from
**Southern
Water**

Our ref
PLAN-032445

Proposal: Demolition of existing dwelling & outbuildings & erection of 7 No. dwellings comprising 3 No. 4 bed houses, 1 No. 3 bed house & 3 No 2 bed houses. This application is a Departure from the Development Plan.

Site: Y/33/20/PL: - Sunnymead North End Road, Yapton, BN18 0DL.

proposed site plan 1:200

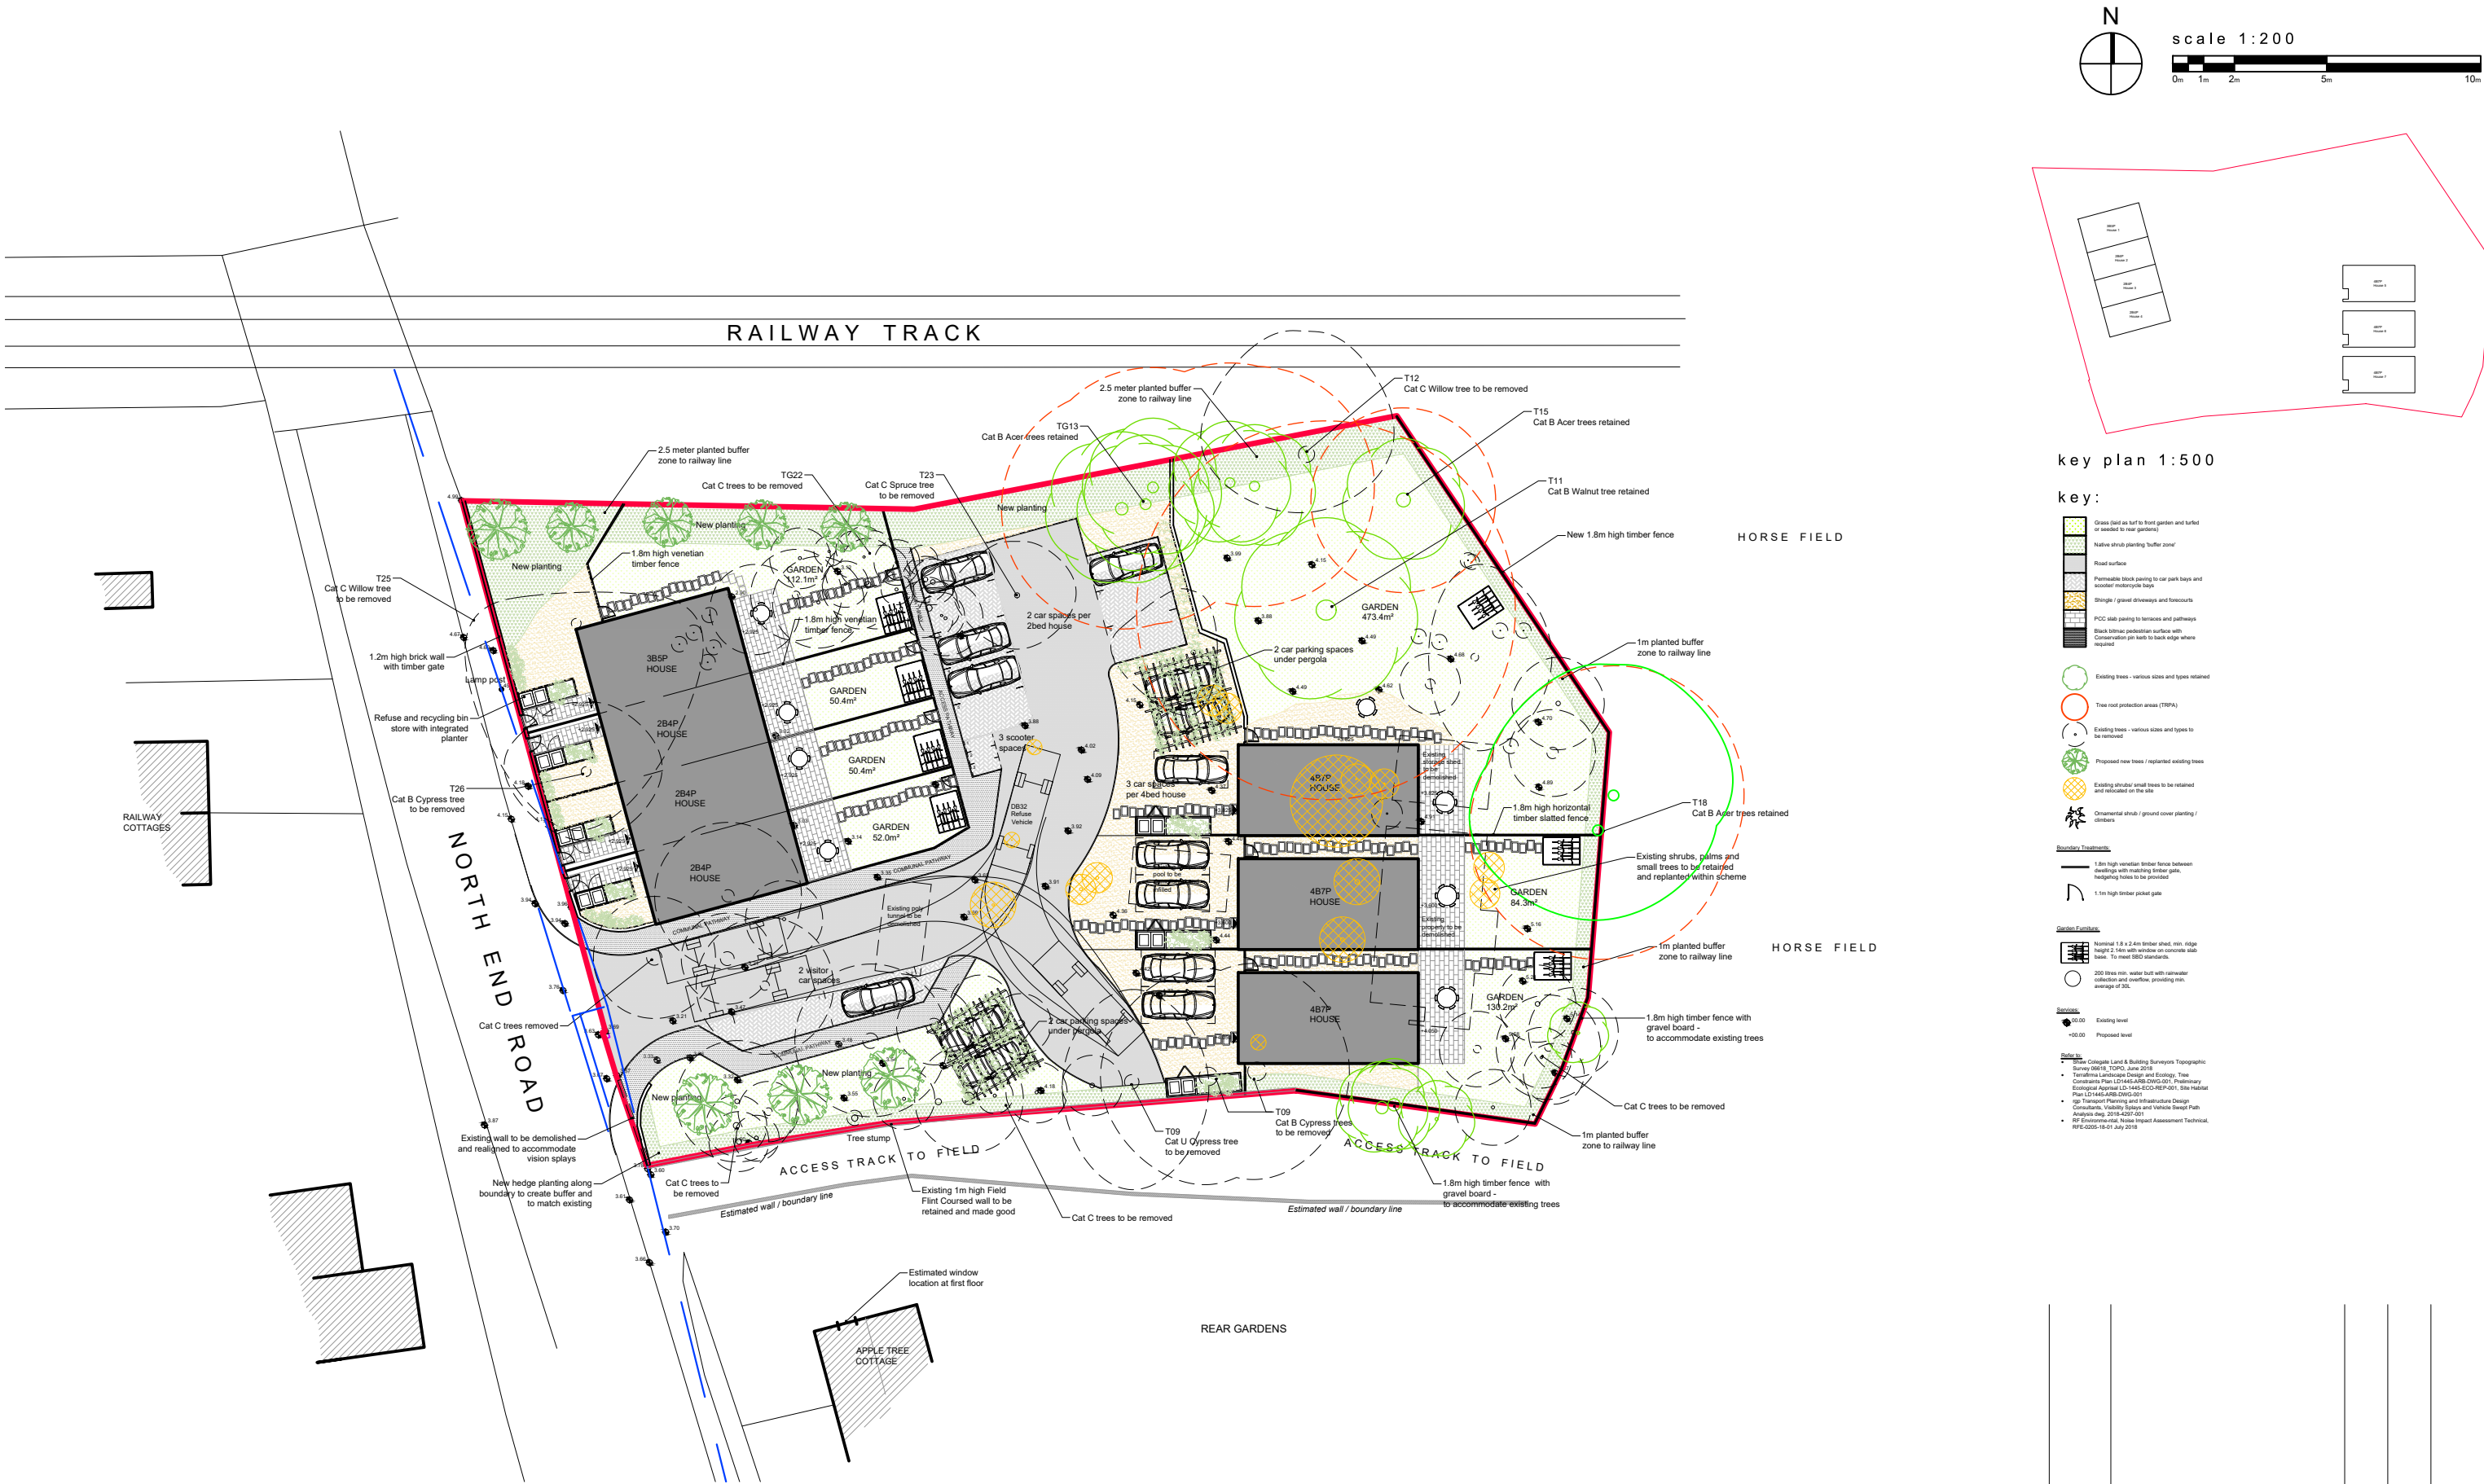
Please find attached a plan of the sewer records showing the approximate position of a public foul sewer crossing the site. The exact position of the public sewers must be determined on site by the applicant before the layout of the proposed development is finalised.

- The 175 mm diameter gravity foul sewers require a clearance of 3 metres on either side of the gravity sewers to protect it from construction works and to allow for future access for maintenance.
- No development or tree planting should be carried out within 3 metres of the external edge of the public gravity sewer without consent from Southern Water.
- No soakaways, swales, ponds, watercourses or any other surface water retaining or conveying features should be located within 5 metres of a public sewers.
- All existing infrastructure should be protected during the course of construction works.

In order to protect drainage apparatus, Southern Water requests that if consent is granted, a condition is attached to the planning permission. For example, "The developer must advise the local authority (in consultation with Southern Water) of the measures which will be undertaken to protect the public sewers, prior to the commencement of the development."
